Our Ref: 001/2021/01 - Please quote in all correspondence.

DC/20/05507- Land Adjacent To Brome Grange Hotel – Highways Statement

I refer to your request for highway advice concerning your proposal for development on this site principally for the erection of commercial units, accessed off A140 and utilising the existing access of Brome Grange Hotel. For latest Site Layout Plan, Drawing TAB550-02E, refer Appendix A.

Rev	Date	Description
		Client
		Mr Keane
		Project Name
		Land R/O Brome Grange Hotel
		Drawing Title
		Proposed Site Plan
		Scale @ A1
		1:1250 & 1:200
		Date
		19.07.2022
		Drn by
		CF
		REV
		Drawing No.
		TAB550-02

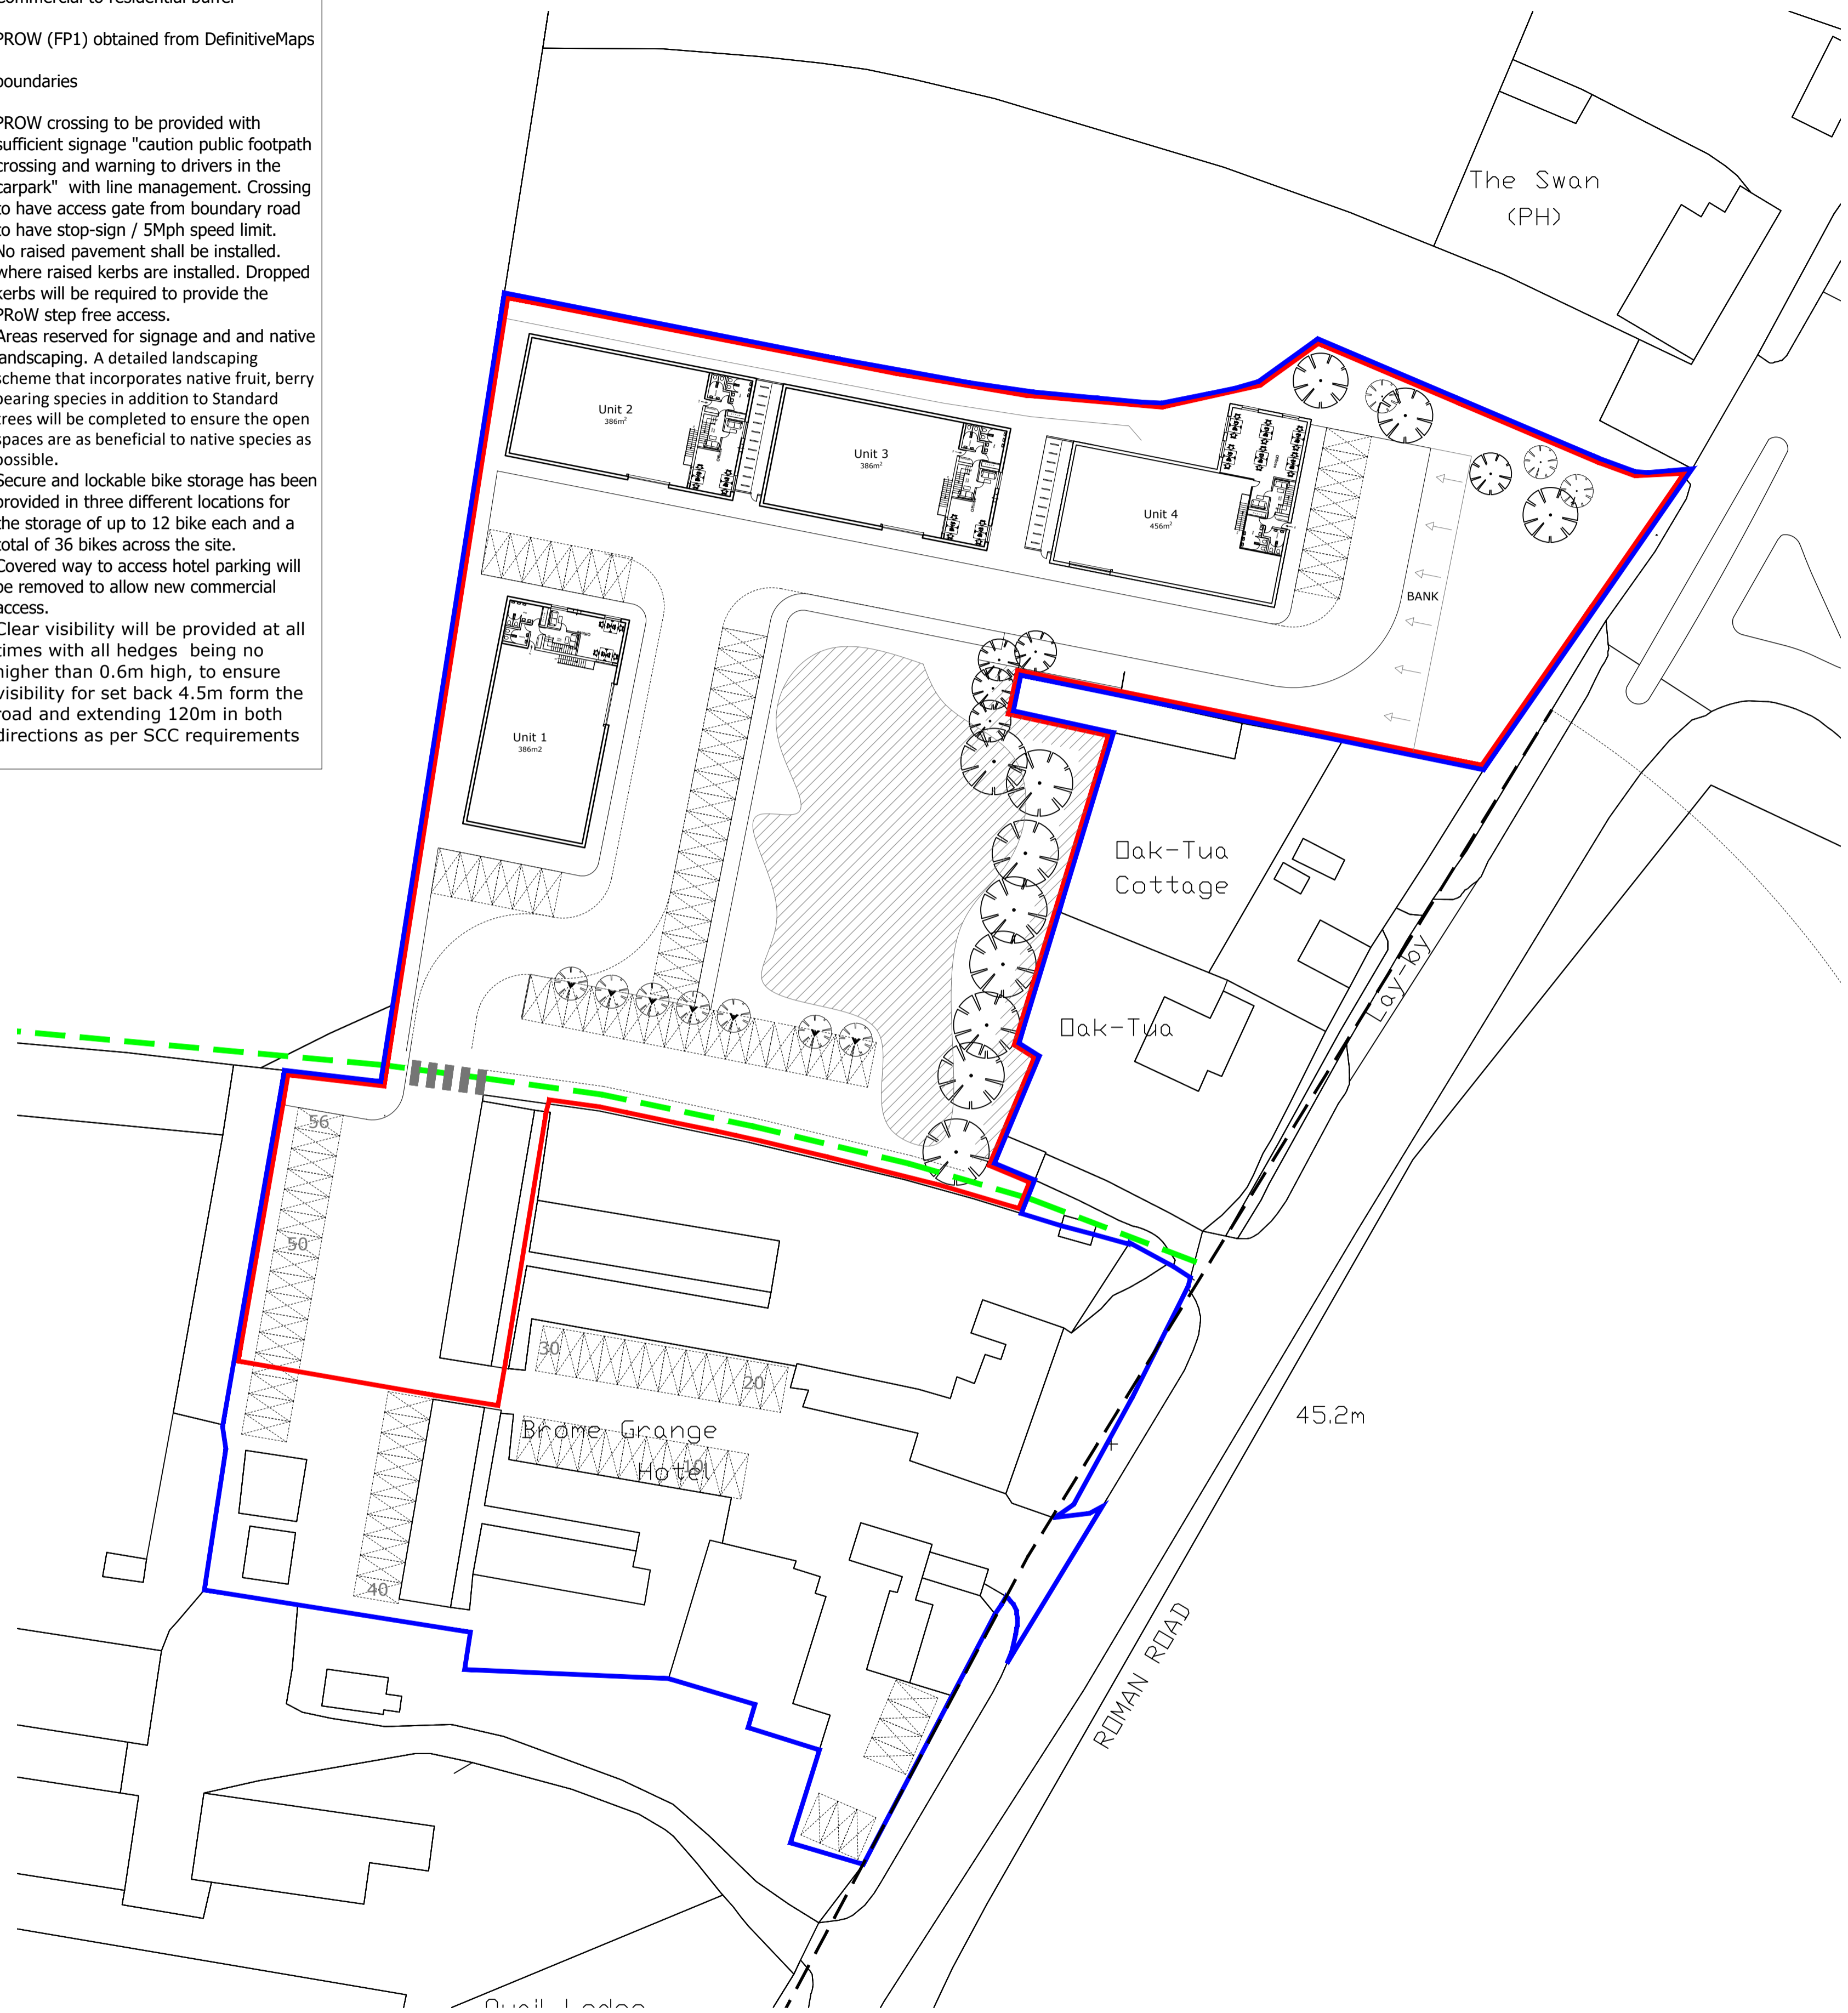
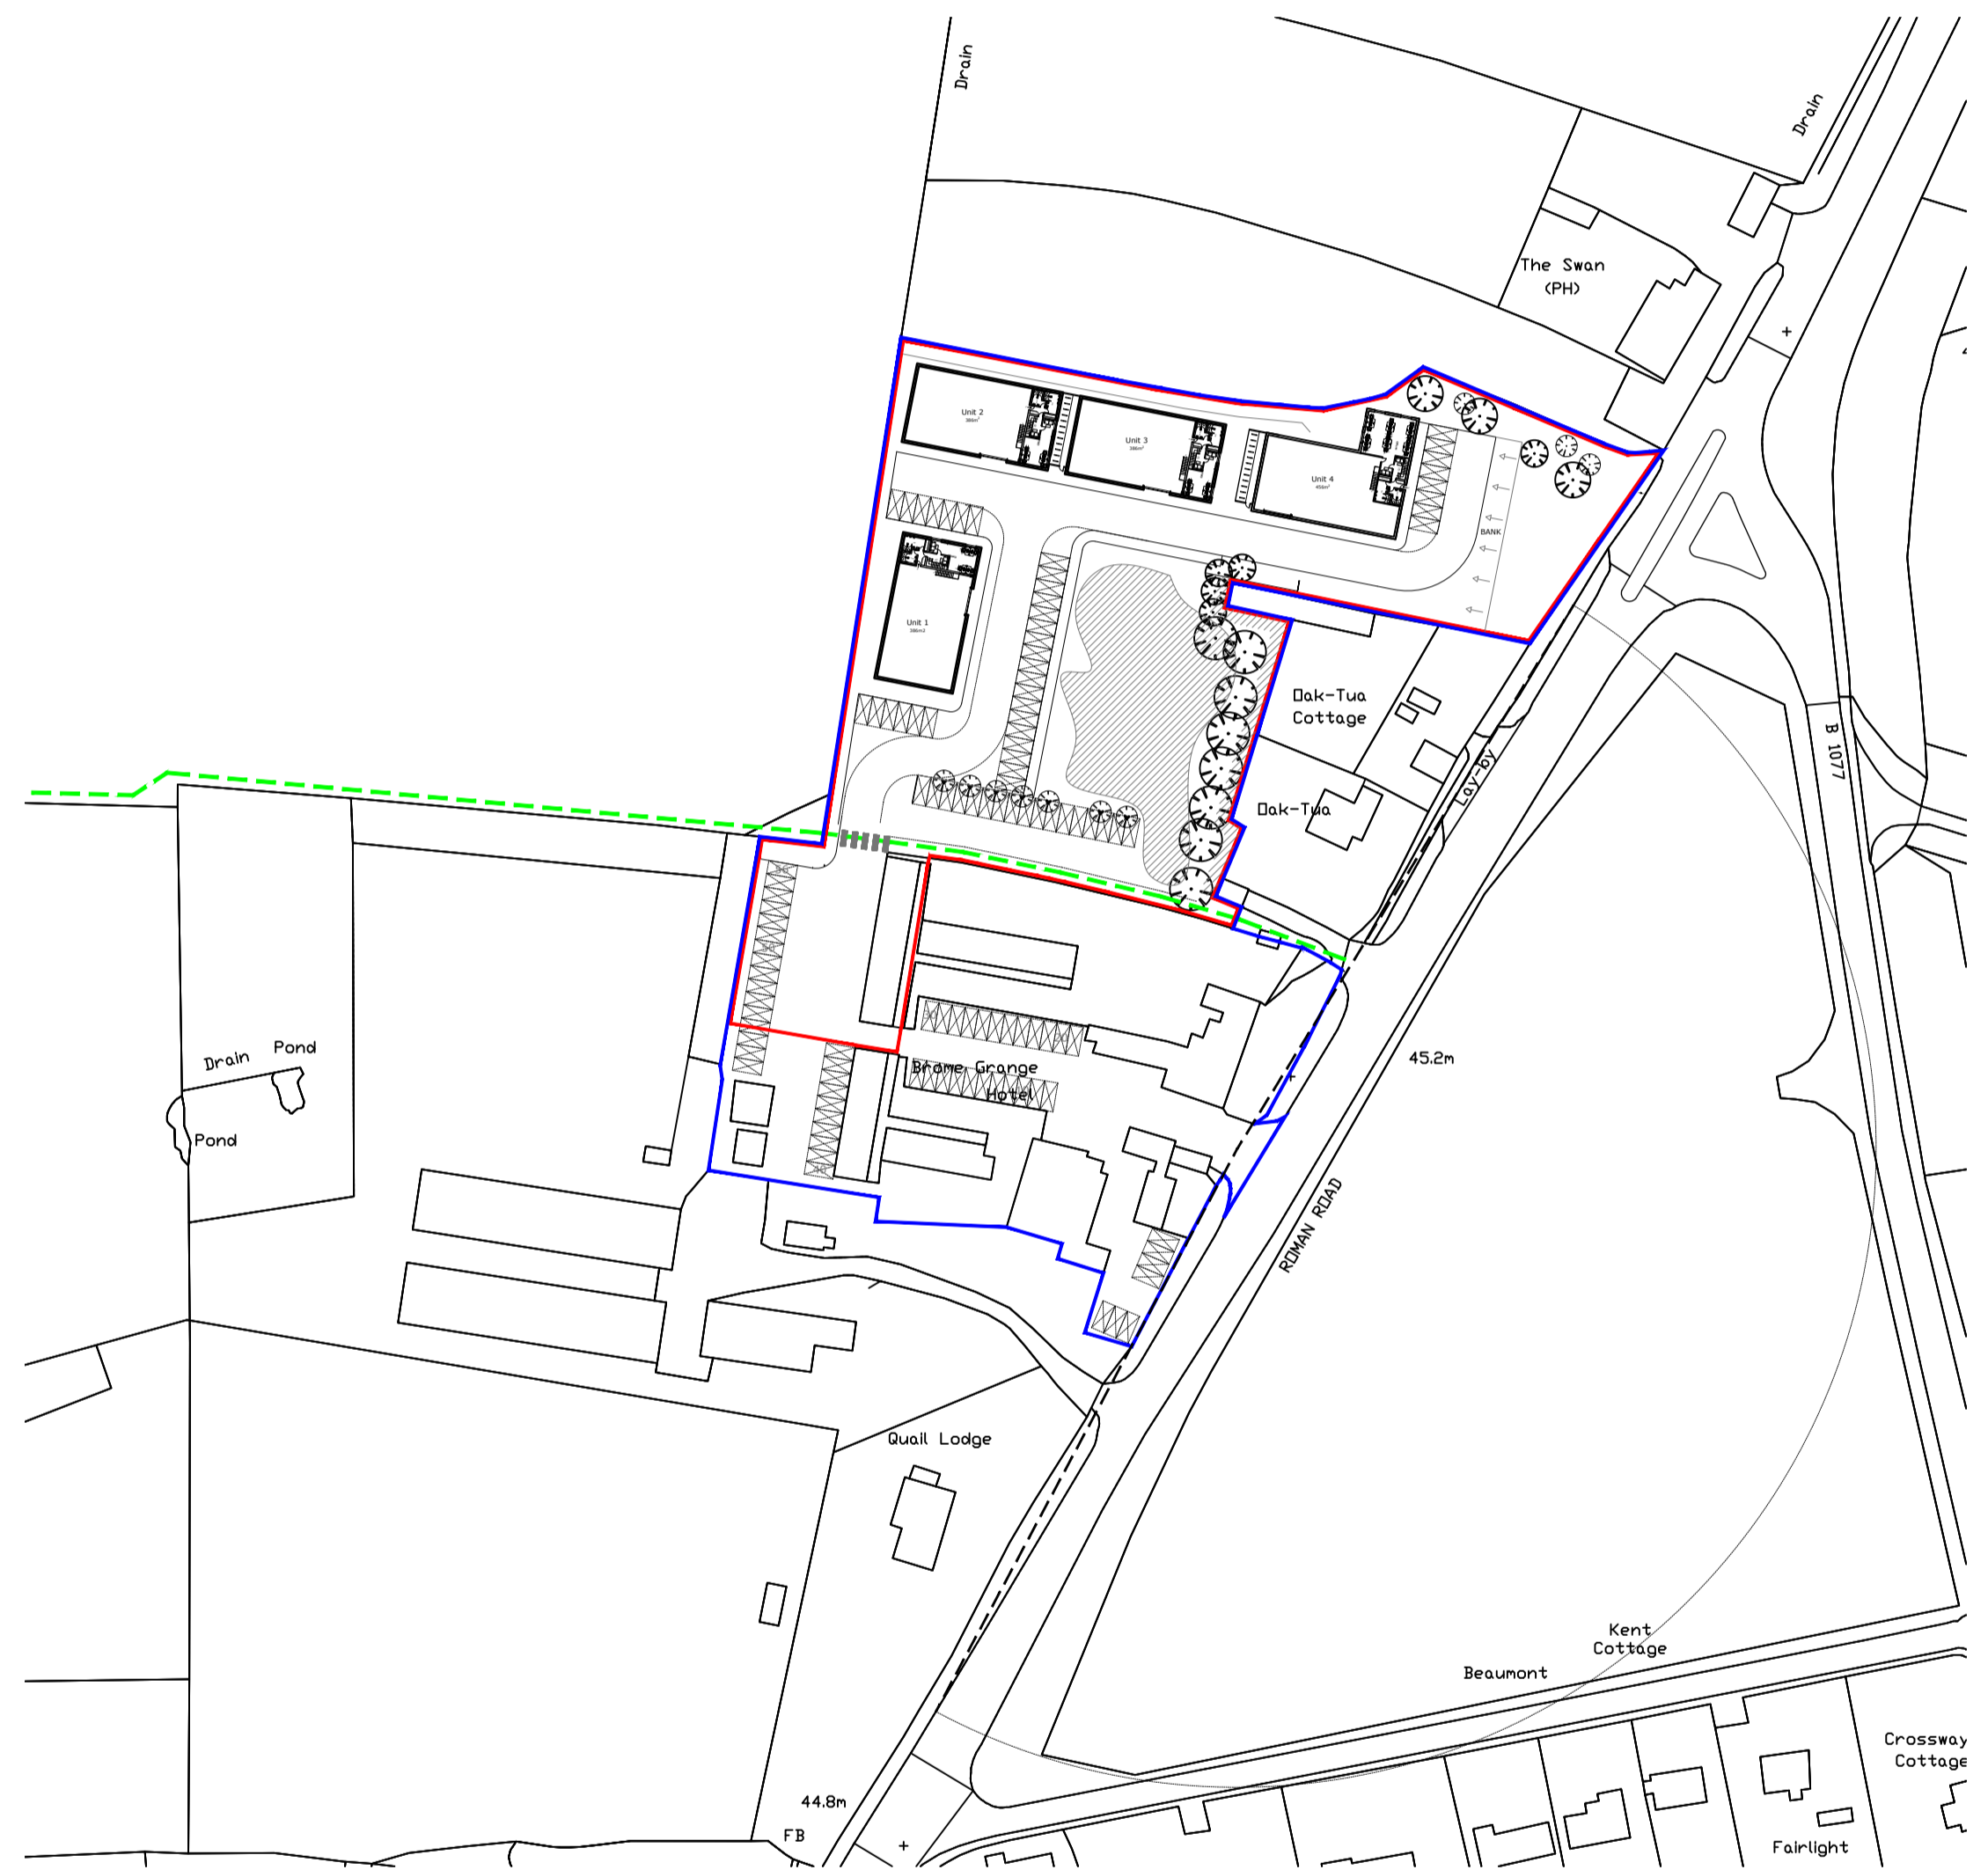
A plan showing the visibility splays for the existing access has not been provided. Adequate visibility is required to safely facilitate the intensification of use the development would create. Norwich Road is the A140 and the required Visibility splay dimensions for a 40mph speed limit road is X=2.4m and Y=120m as stated in Design Manual for Roads and Bridges. If the required dimensions cannot be met, the proposed vehicular access will not safely facilitate the intensification of use the development would create.

Please note, the PROW team response 'We object to this proposal on the basis that the Applicant has not been clear about how they are going to accommodate FP1, the line that is shown on the plans does not appear to be the legally recorded line of the path'. If this can be looked at by the applicant, then there will be no outstanding issues with regard to highways.

The latest drawing TAB550-02E, as set out in Appendix A now demonstrates the achievement of the required visibility splays. In fact, a greater visibility is achieved than that required by SCC, achieving x=4.5 m and Y=120 m, is shown as achieved (refer drawing note 5.). Given the required dimensions can be met, the proposed vehicular access will safely facilitate the intensification of use the development would create. This will therefore be acceptable to SCC and meet their safety standards.

The applicant and architect are in direct liaison with SCC PROW team, to address their previous holding objection. The latest site layout plan corrects the PROW recorded line of the path, extract below.
